Our Ref: 21/00366/FUL
Your Ref: 51 Farlington Road -
DUAL

LOCATION: 51 Farlington Road, Portsmouth, PO2 0DS,

PROPOSAL: C3 use to Dual use C3 Residential / C4 HMO use. **(21/00366/FUL)**

5 Proposed Rear
1 : 100

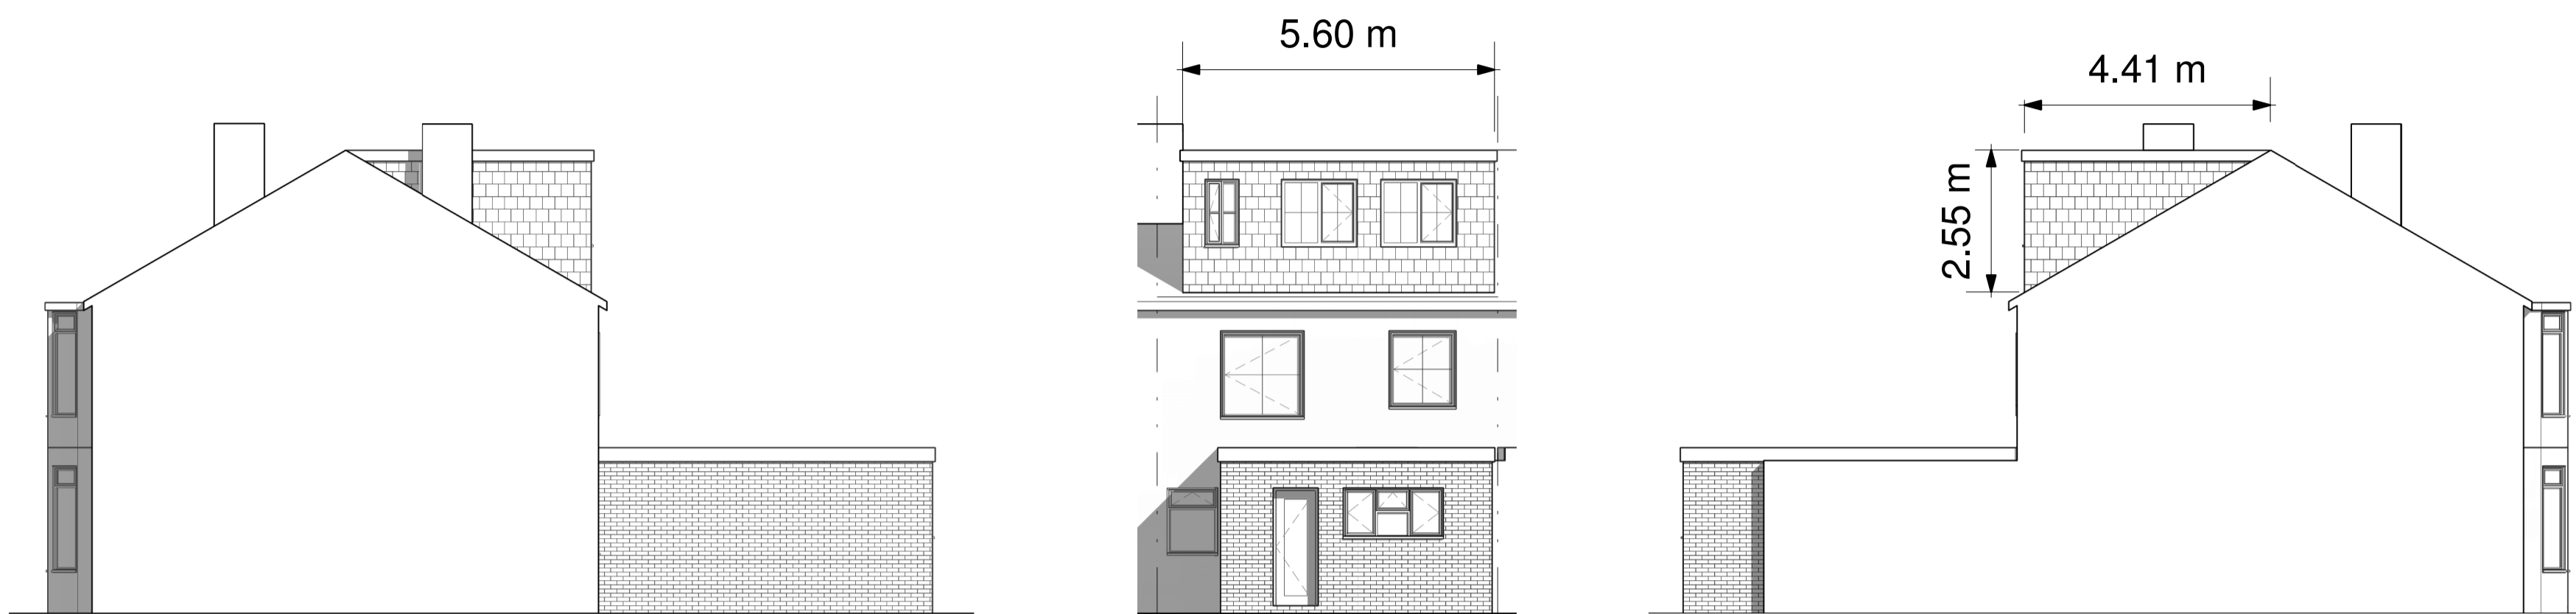
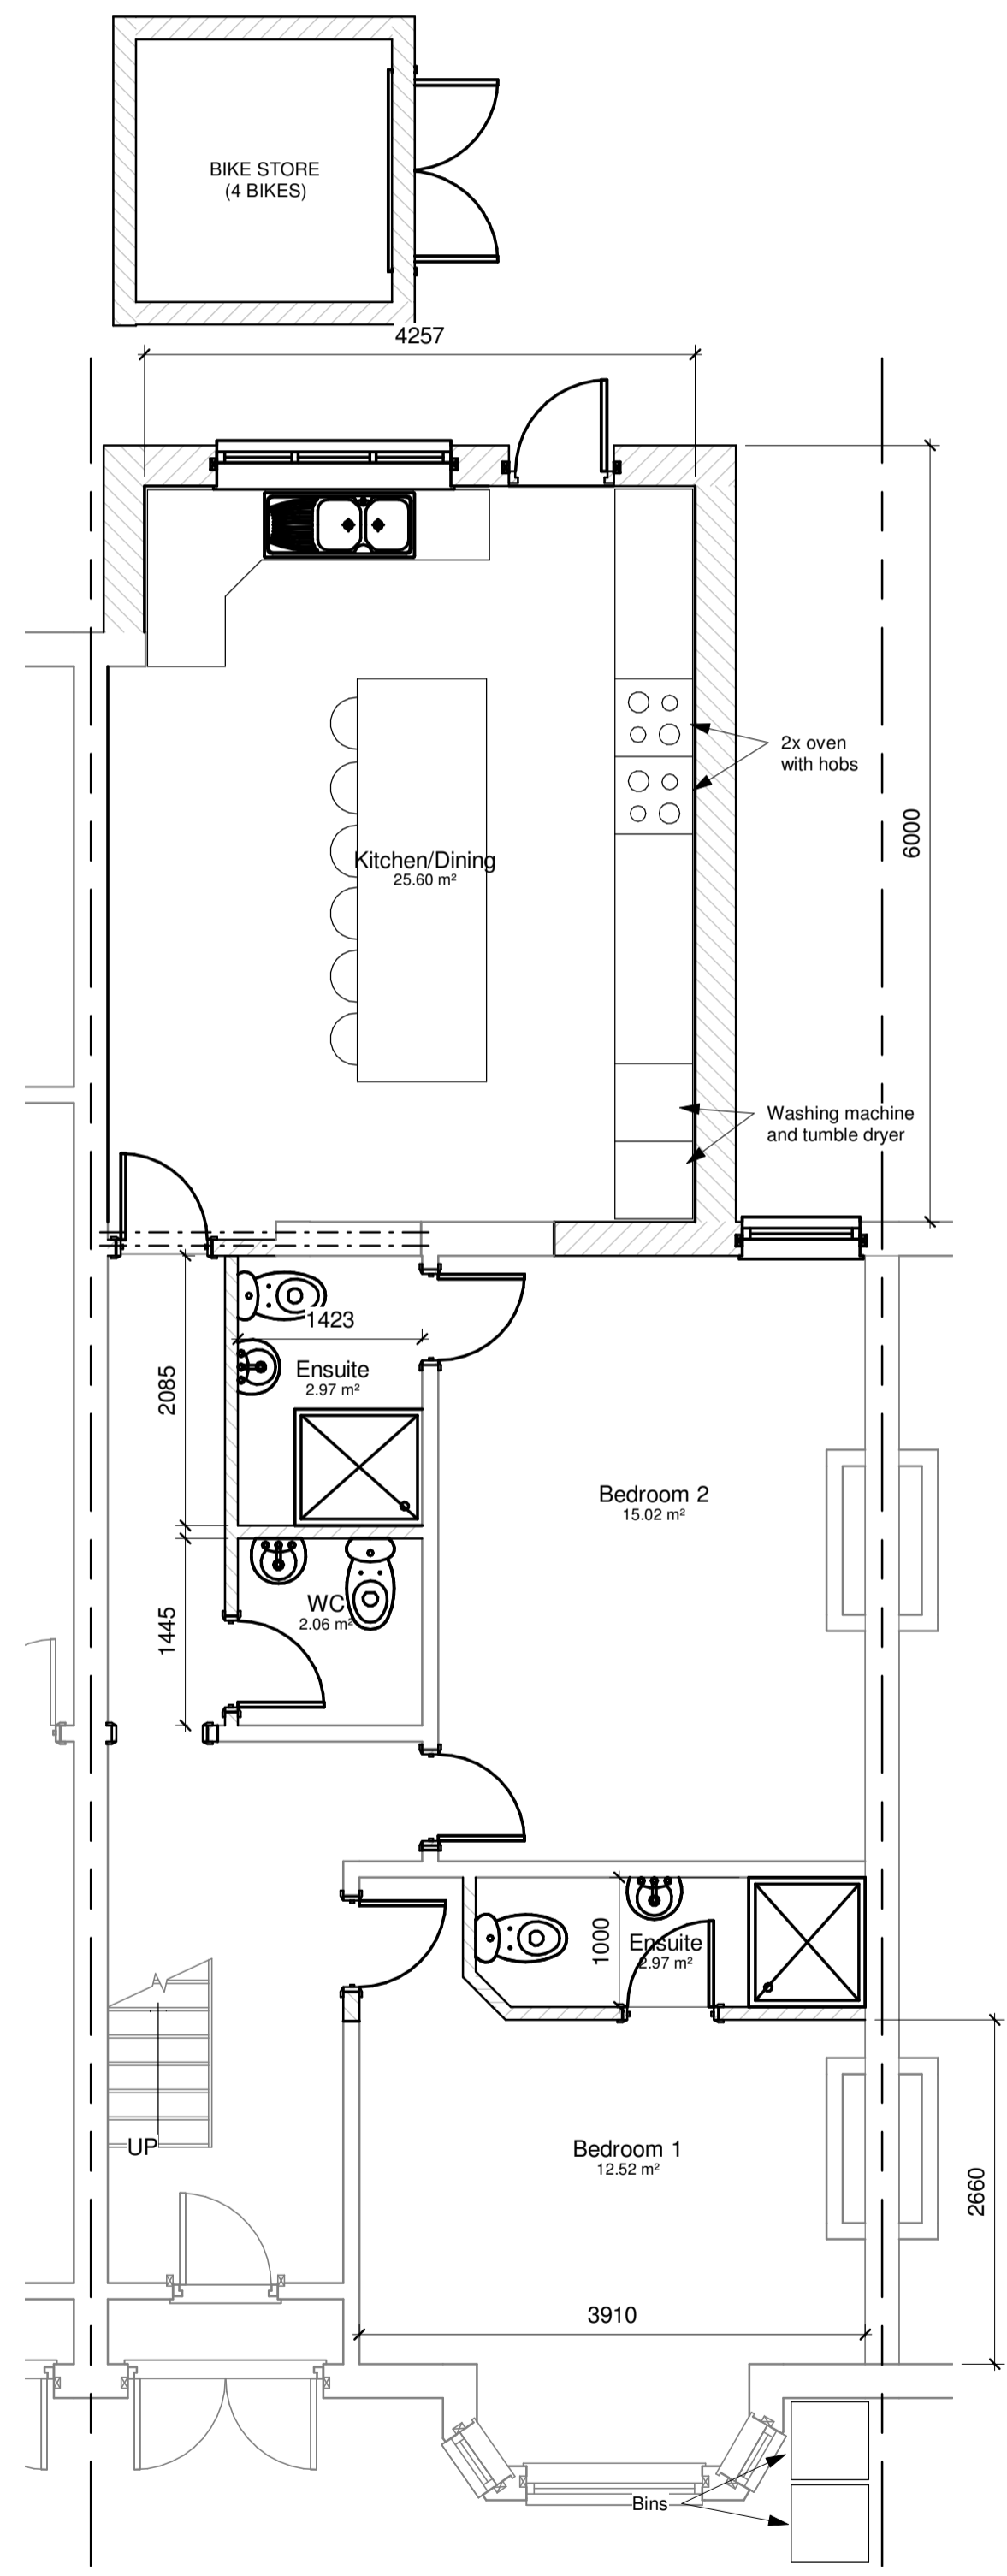
- 1) Please submit drawing drawn to a metric scale of 1:50 or 1:100 showing the existing elevation or site photos of the existing rear and front of the property.
- 2) Please submit drawing of the proposed elevations showing the rear dormer roof extension at a scale of 1:50 or 1:100 with a scale bar.
